A1 in Northumberland: Morpeth to Ellingham

Scheme Number: TR010059

7.32 Applicant's Responses to Deadline 8 and 8a Submissions

June 2021

Figure 1 - Original Proposals for the River Coquet Crossing

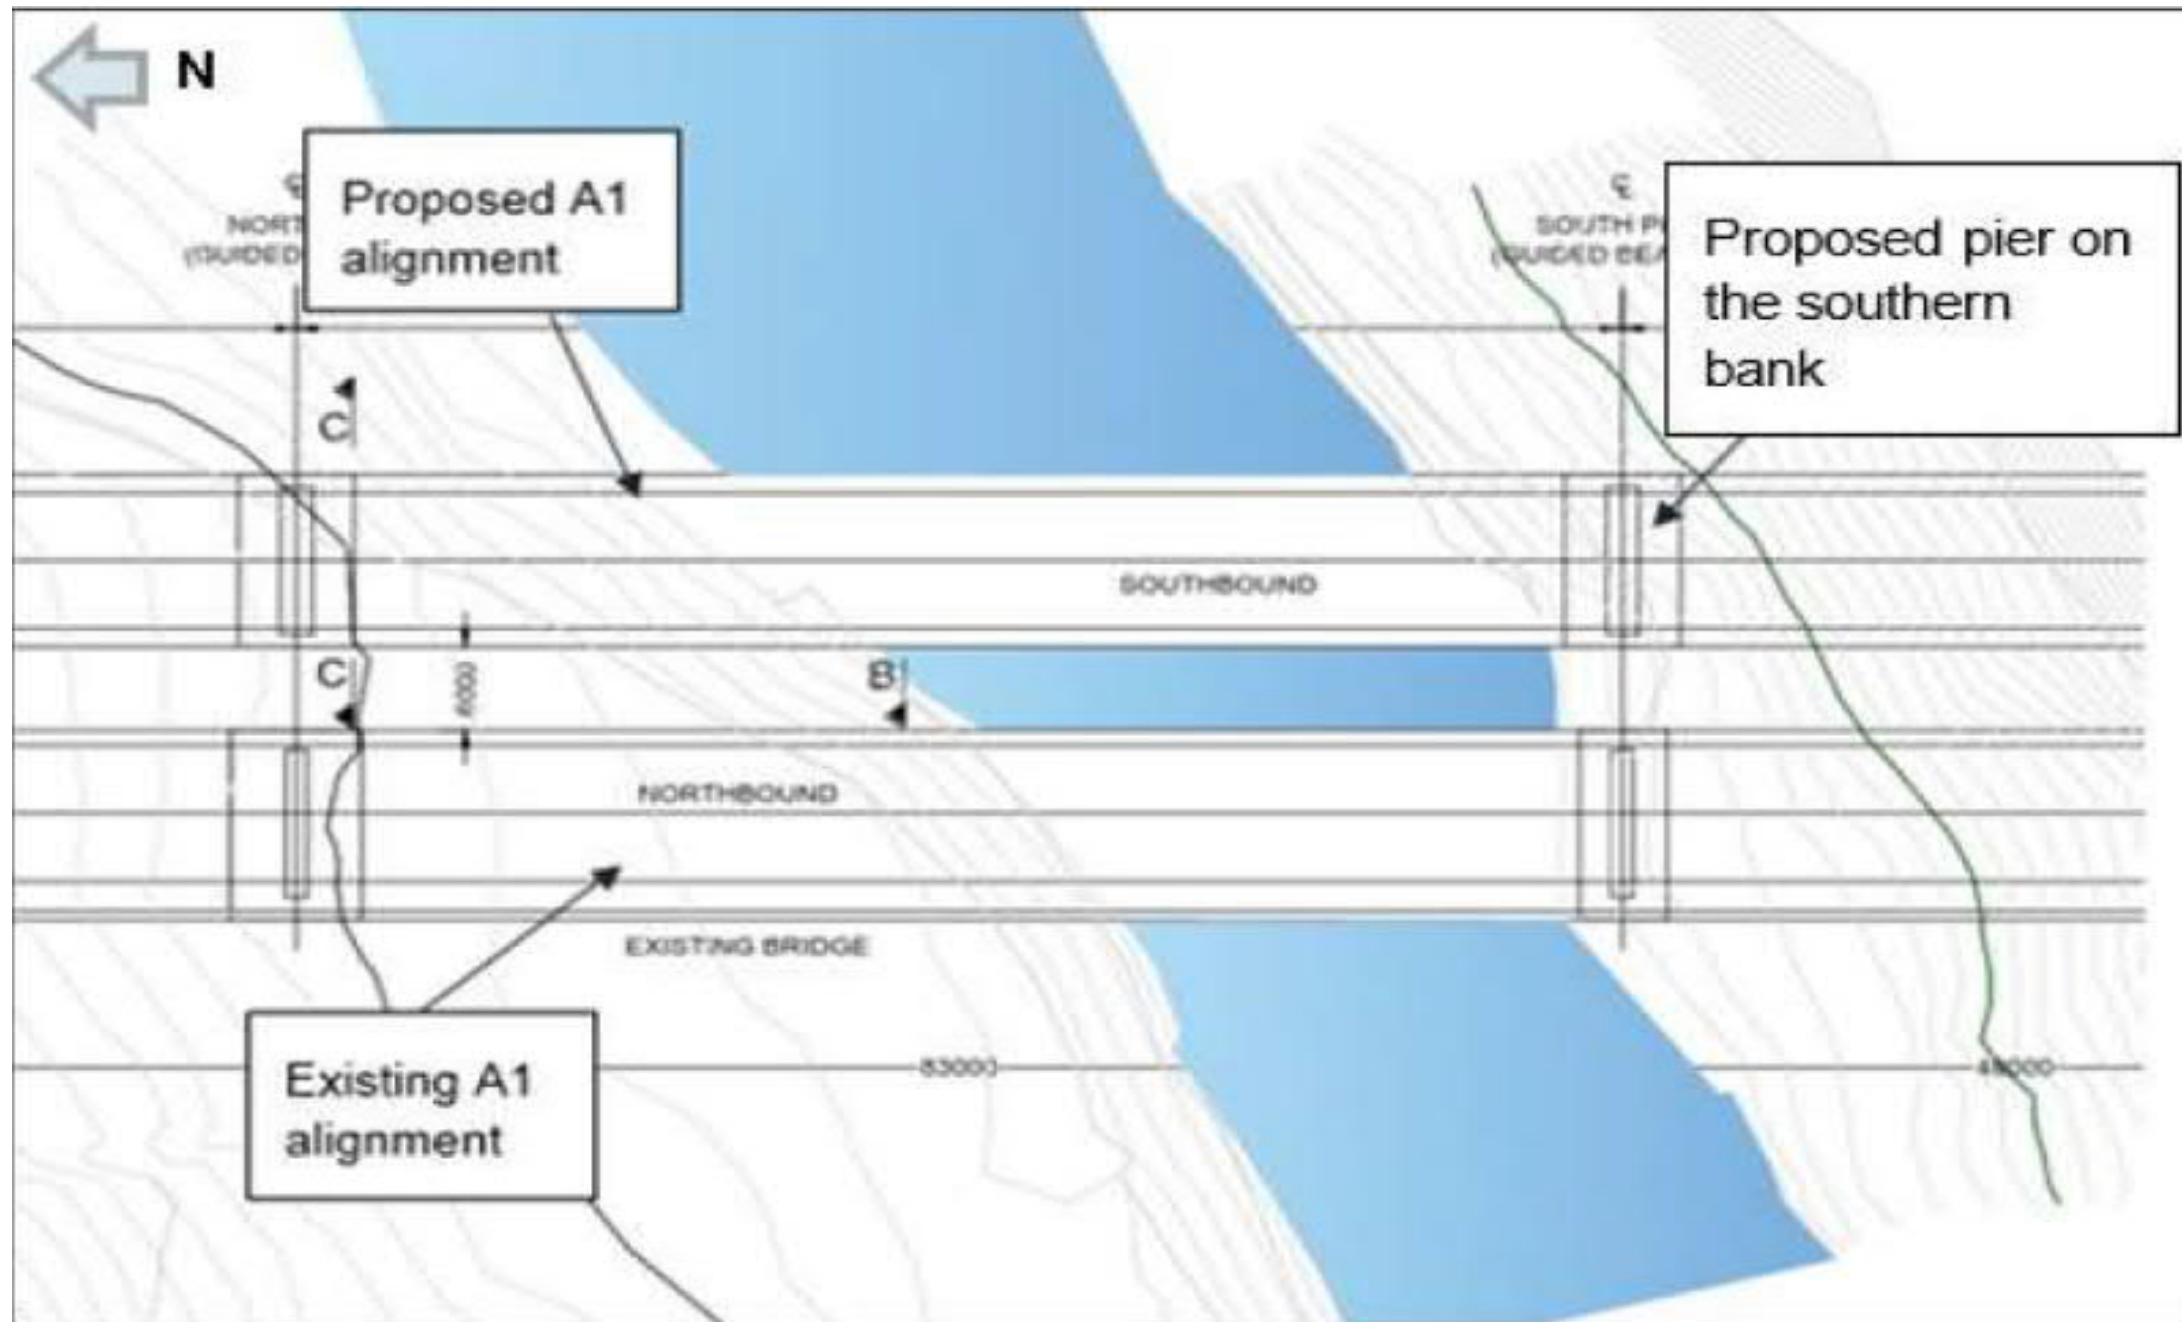
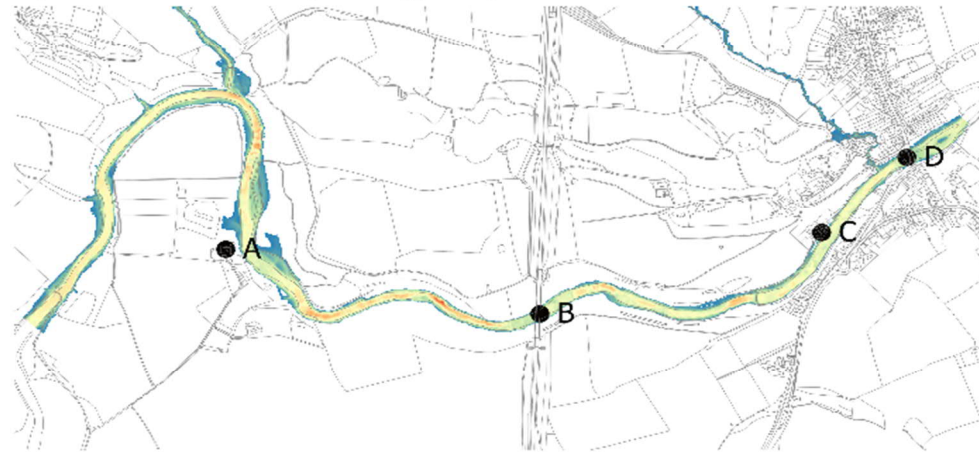
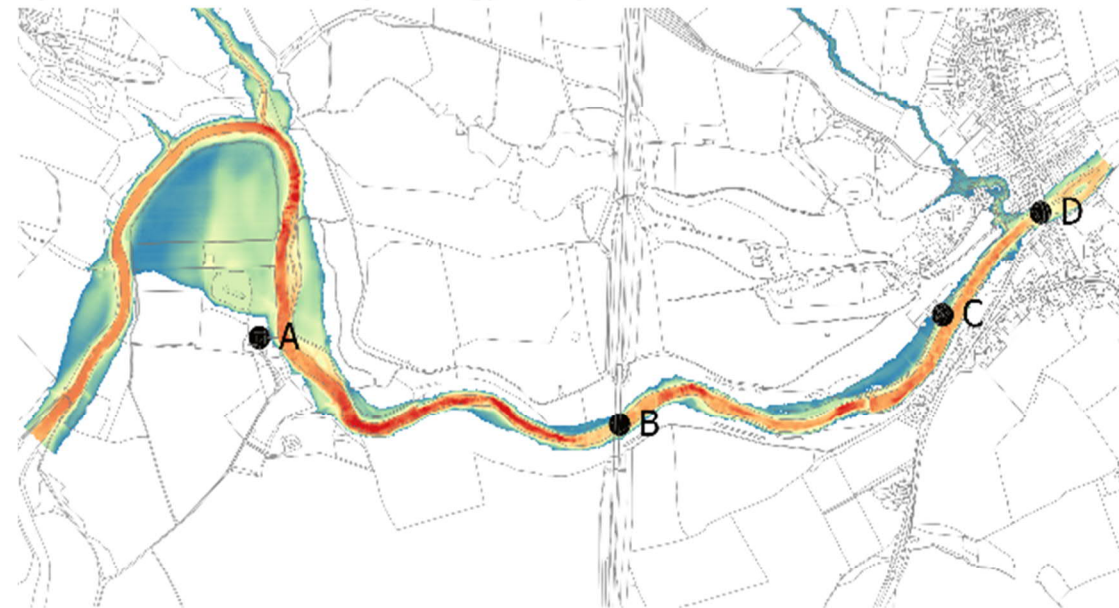
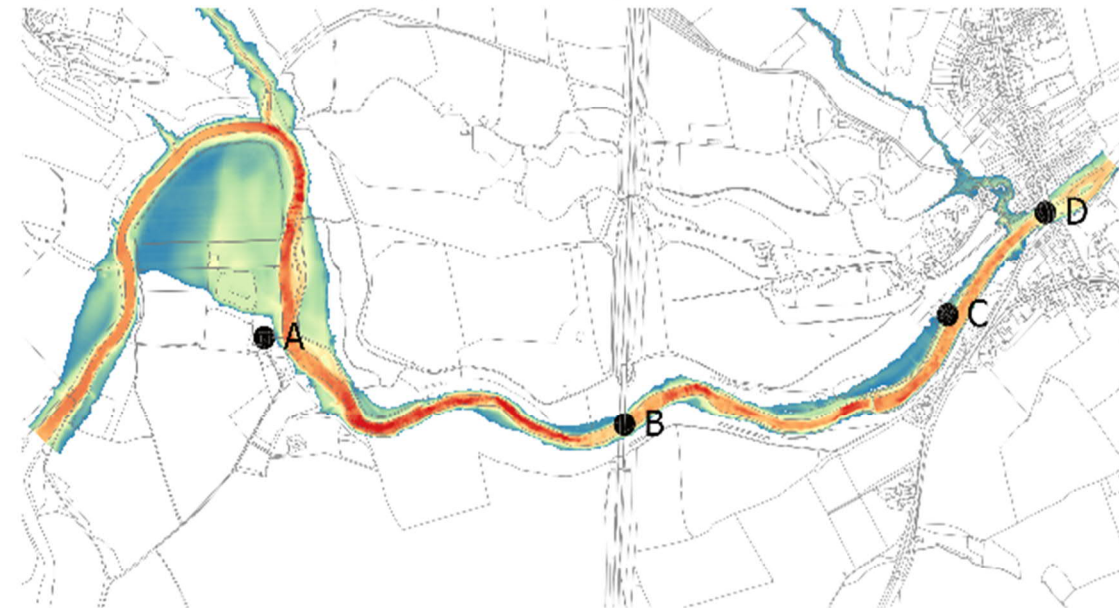
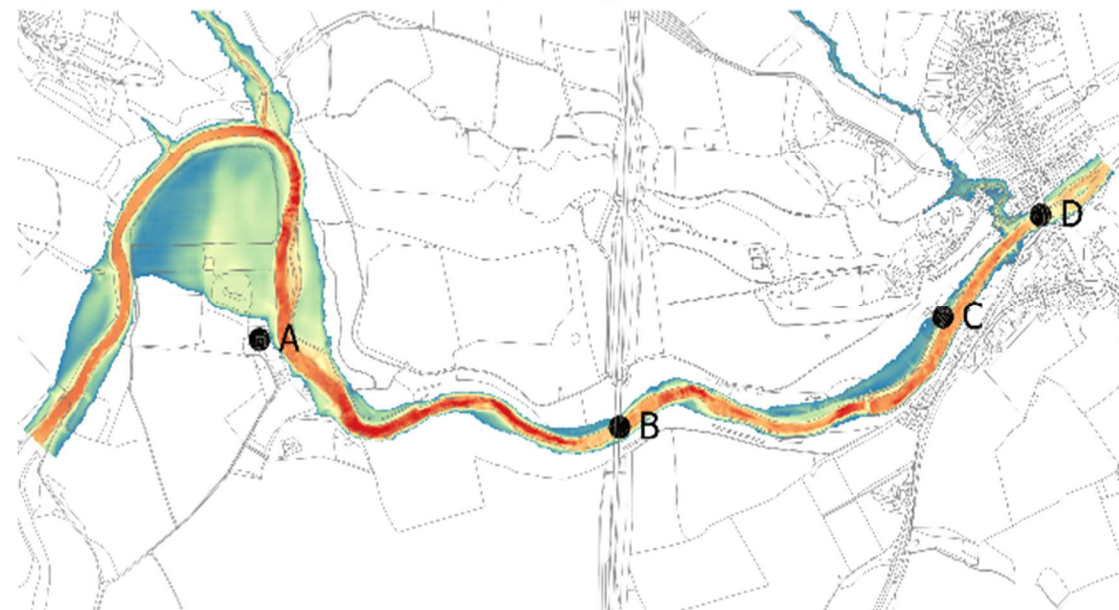
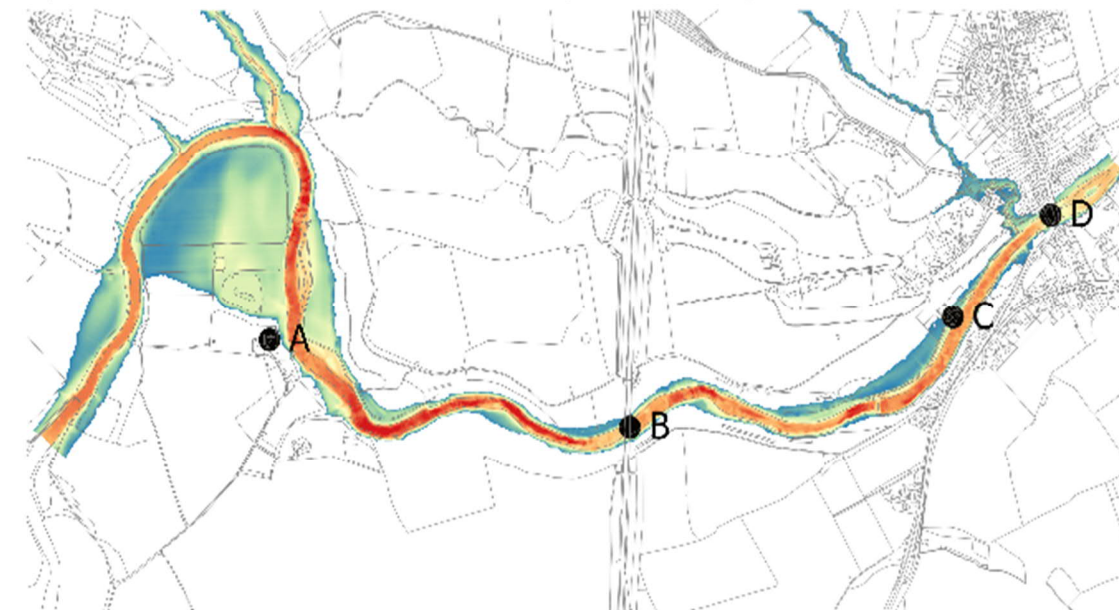
Deadline 7 Submission - 7.9.1.2 Flood Risk Assessment Addendum - River Coquet - Rev 1 [REP7-015]		
2	The submitted Flood Risk Assessment Addendum addresses the points raised in our previous written representations. The Hydraulic Models which form the basis of this addendum are currently under review with our modelling team. We will submit our position on the hydraulic model following the completion of the review.	<ol style="list-style-type: none"> 1. The Applicant notes that the Environment Agency confirms that Flood Risk Assessment Addendum - River Coquet [REP7-015] addresses the points raised in previous written representations. 2. The Applicant notes that in their Deadline 8a Submission - Responses to ExQ4 [REP8a-013], the Environment Agency confirms that the model review is now completed and that the baseline, construction and operational models are considered reasonable. An updated hydraulic modelling report (River Coquet Hydraulic Modelling Report [REP8a-004]) was submitted by the Applicant at Deadline 8a which addressed comments raised by the Environment Agency following their review of the Applicant's baseline hydraulic model.
